From [REDACTED]
Sent: Friday, October 13, 2023 2:24 PM
To: [REDACTED]
Cc: [REDACTED]
Subject: RE: Farm Building, Manor Farm Old Lane, Davenham - ref: 2100/23/BN

Kind Regards,
[REDACTED]
Building Control Surveyor
Regulatory Services
Cheshire West and Chester Council

Title: **COMMENCEMENT PLAN
(LOCATION OF
FOUNDATIONS)**

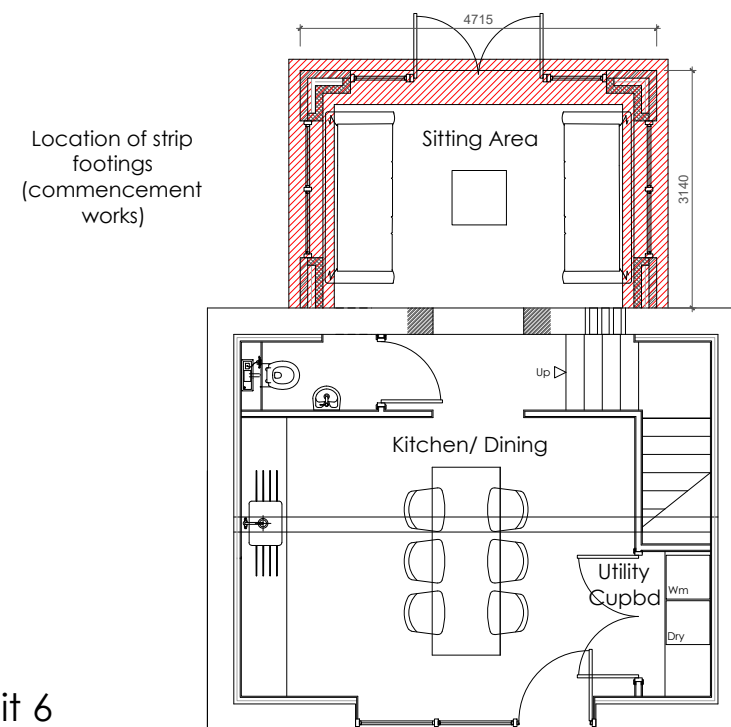
John confirmed the depth of the excavation is 1m below external ground level to clay, this is deemed acceptable to us. Please note, the excavation will need pumping and bottoming out prior to placing concrete. I would also advise taking photos of when they are cleared please.
